## WEDDIN SHIRE COUNCIL

7 February 2022

**RE: SSD – 13855453 – Grenfell Poultry Breeder Farm  
Lot 1 DP 1022013, Lots 1-3 DP 1206485 and Lot 22 DP 866857**

DRAWING TITLE	EXIT TO GOOLOOGONG SWEEP PATH
CLIENT	BAIADA
PROJECT	GRENFELL FARMS
LOCATION	1130 GOOLOOGONG ROAD, GRENFELL, NSW

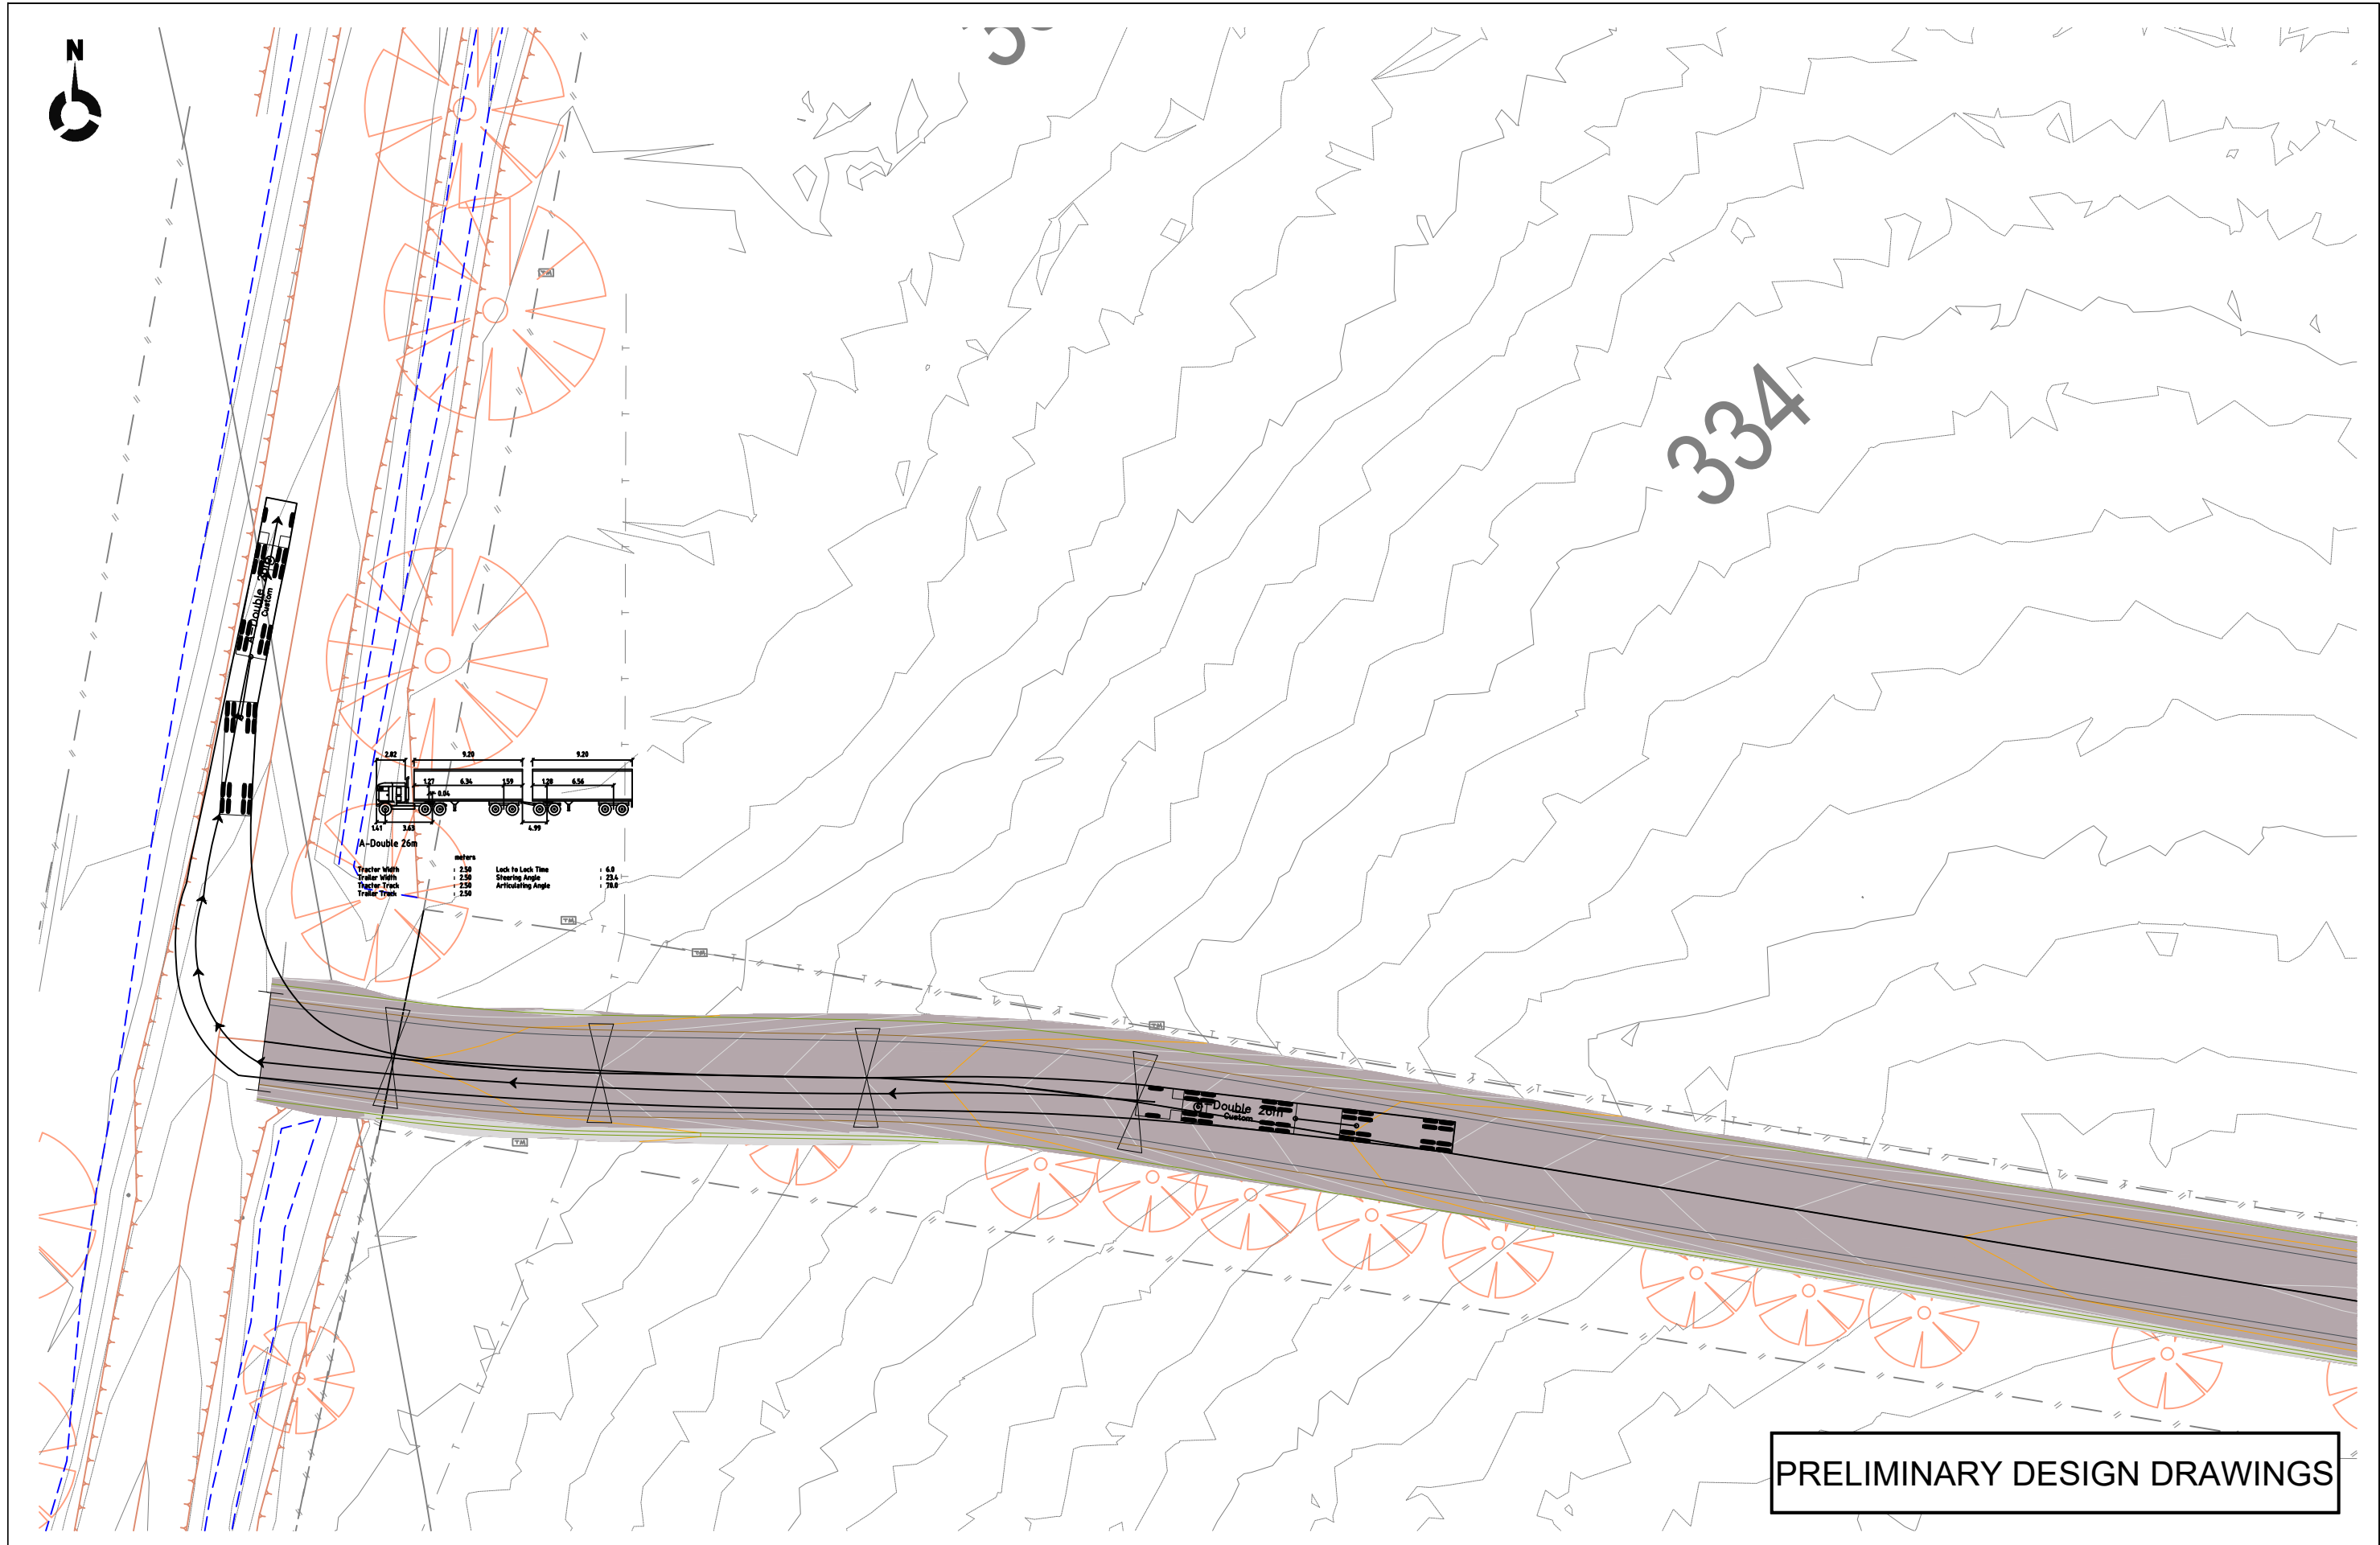
Access to the development will be gained via Gooloogong Road, which is a classified road. While Transport for NSW is likely to have a number of requirements for the vehicular access to the property, Council considers it important that any access to the site is adequately sealed and compliant with Austroads standards, in particular encroachments of vehicle turning paths at the intersection.
